RE: Planning application No: 3/2023/0032

Proposed two storey side extensions and new detached garage/carport at
Fair View, Back Lane, Wiswell

north west elevation

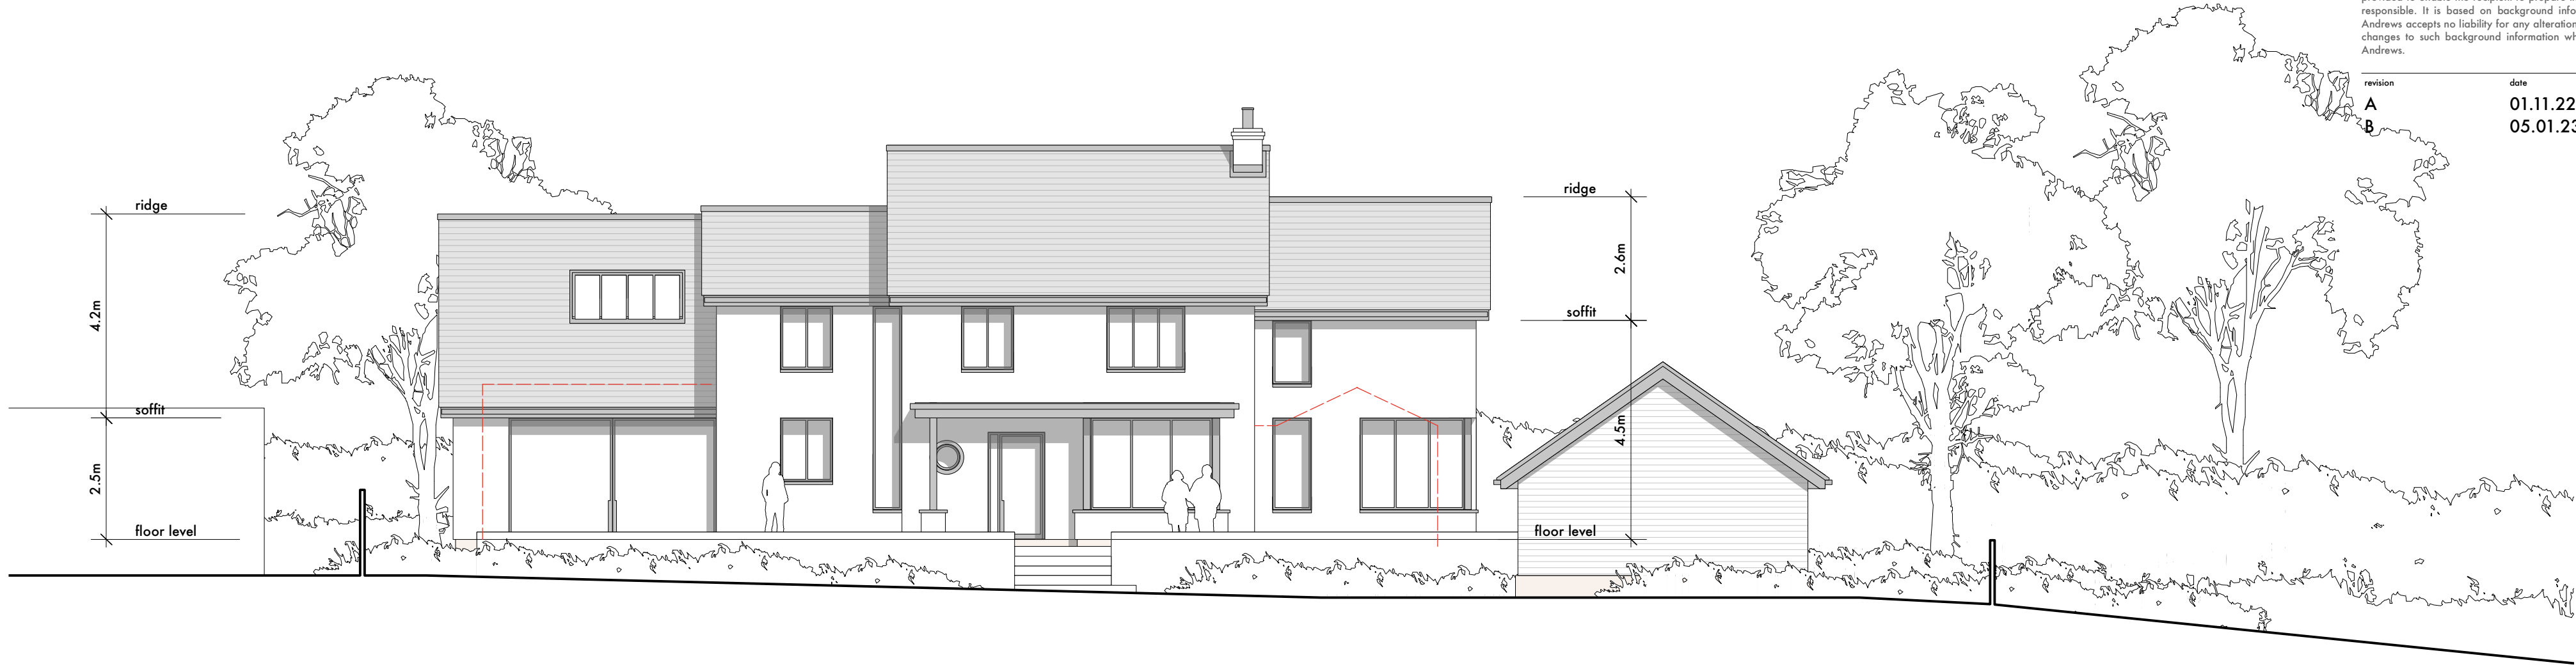
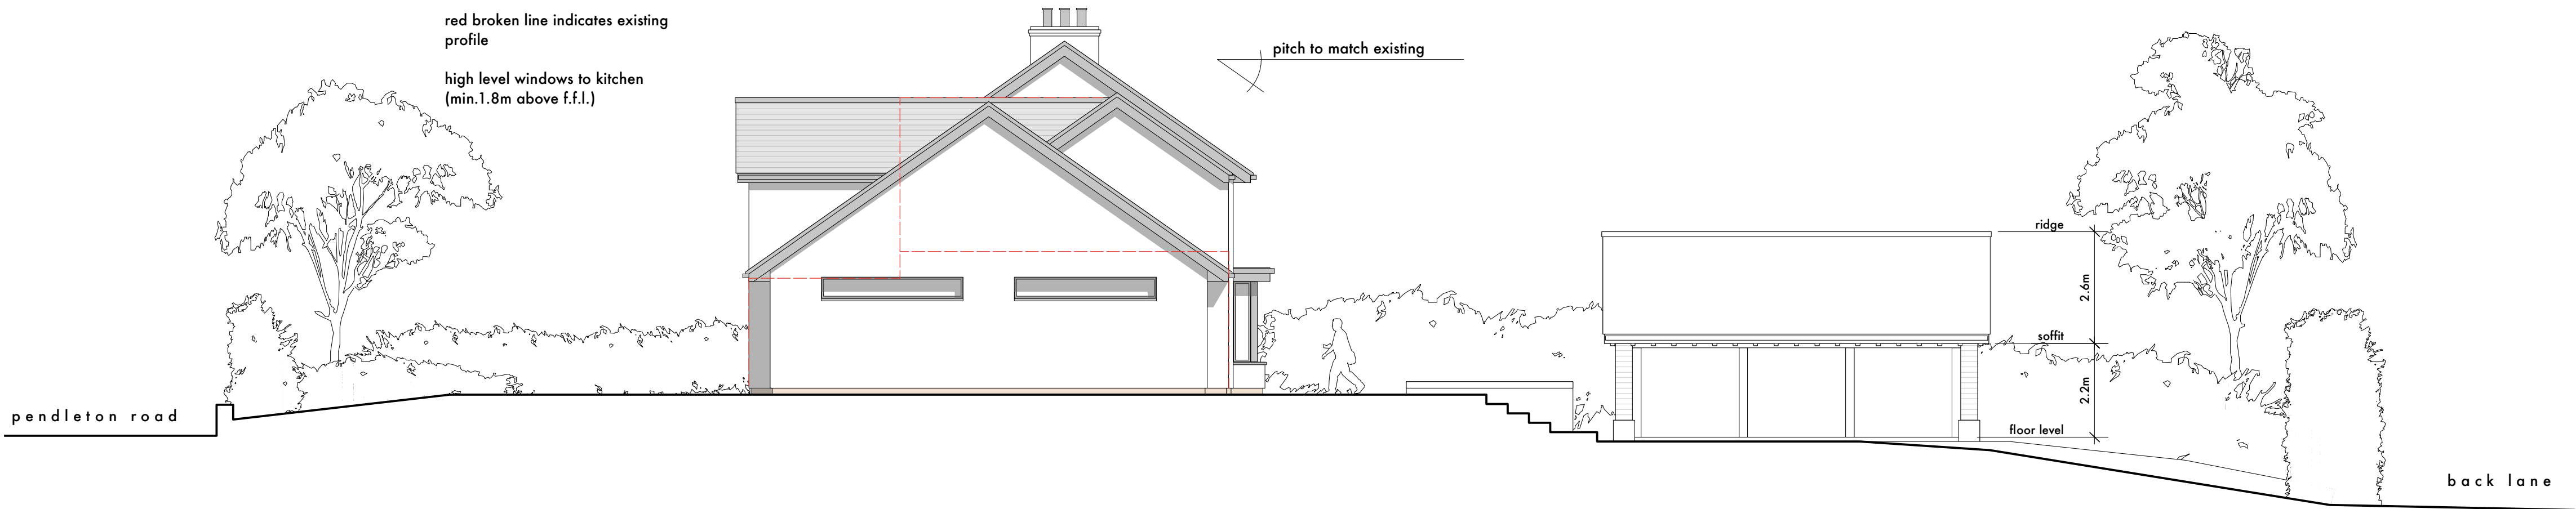
- 1) The Architectural Design and Heritage (ADH) statement sets out the existing and proposed areas. We note that although the proposed footprint is only 4% increase, the two side extensions result in an extensive increase in total size of the house due to the overall increase in height.

- 2) This increase in the overall height of the building with the two side extensions will increase the shadow of Fairview so that any afternoon and evening sun will be blocked from the properties on Pendleton Road.

- 3) The SW view of the proposed extensions pictured on the ADH statement is misleading as it fails to illustrate the new dormer windows on the north side extension. These are set higher than the existing windows on the east facing wall and will directly overlook our property and garden and will impact our right to privacy.

- 4) The ADH statement makes particular reference to the existing screening around the property. However, is it the applicant's intention to lower the surrounding hedges as suggested in the drawings? If so, this would make the house far more intrusive and will allow all the windows to overlook our house with the consequent invasion of our privacy.
